## Inspector's Report ABP 308254-20

Whether the following works;

Howth Castle, aka Deer Park, Howth, Co. Dublin.

Figure 1: Images of Existing 'Bent Arm Post' Fence Constructed in c. 1973

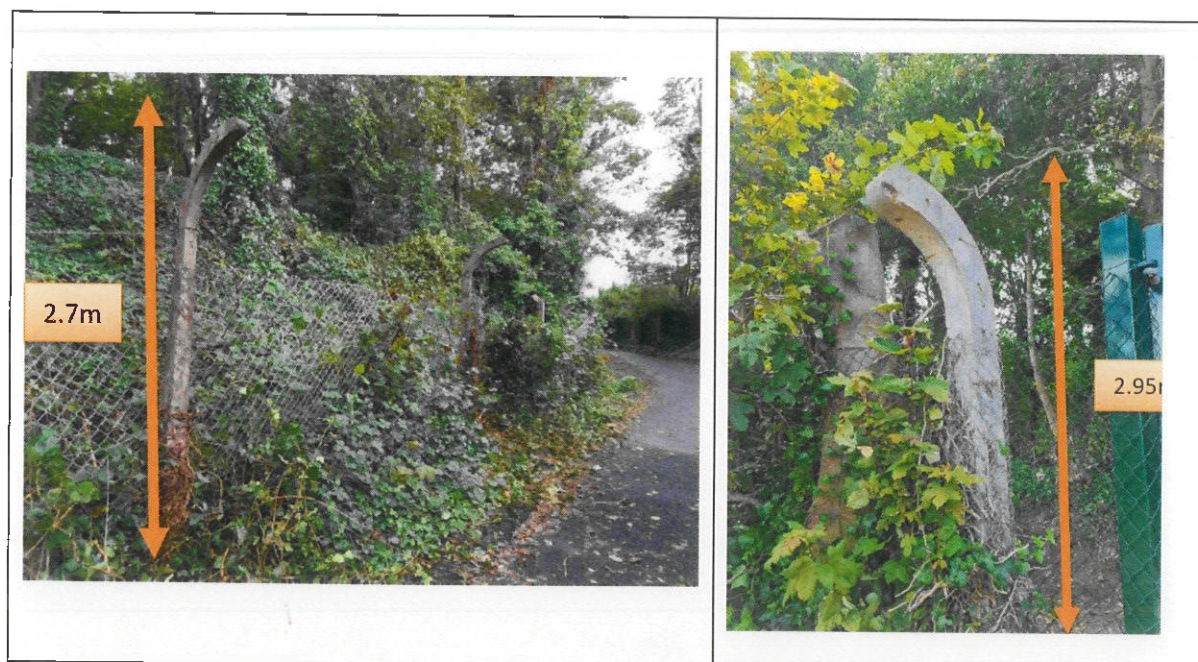
8.2.10. The Referrer details in Figure 1 of the planning report submitted that the original 'bent arm fence posts' have a height of 2.7m – 2.95m. Figure 2 details that the original fence has a height of 2.4m and the bent arm posts have a height of 2.6m. The Referrer states in Section 3.5 of the planning report that '*the fence as constructed in the 1970's, which still exists to date, is already in excess of 2m in height*' and that '*the repairs to this fence which have been implemented provide for the same height as the existing fence*'. The Referrer states in Section 2.0 of the planning report that the '*fence posts have been replaced where necessary*'. I observed during site inspection that the wire lines of the fencing structure extend to the upper part of the bent arm fence posts. Given that the height of the replacement fencing structure exceeds 2 metres, as confirmed by the Referrer, it is my view that the replacement fencing structure does

not comply with the terms of Condition No. 1. On this basis, the replacement fencing structure is not exempted development.
